<b>Consultation Response from KC, Highways Development Management</b>
<b>2025/90527 Land adj, 67, Elm Tree Close, Norristhorpe, Liversedge, WF15 7BU</b>
<b>Change of use of land to domestic garden, formation of access and hard surfacing and erection of 2.0m high fencing, greenhouse and gazebo</b>
<b>Date Responded:3-7-2025. Responding Officer: Mark Berry. Responding Ref: 14-3NW-1.</b>

SITE PLAN 1:200

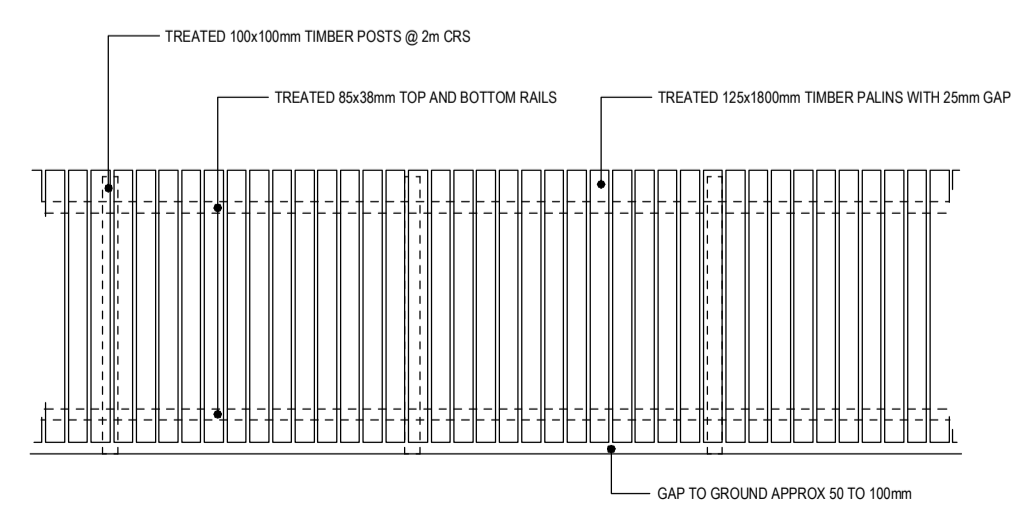
The highways consultation response dated 4<sup>th</sup> June recommended that that the fencing is set back 1.0m to allow suitable pedestrian/vehicle inter-visibility from both footways onto Lodge Lane.

The applicants have provided plans showing 1.5m pedestrian intervisibility splays and not the fence set back as requested.

The fence should be set back to 1.0m from the carriageway edge of Lodge Lane or the red line on the plan.
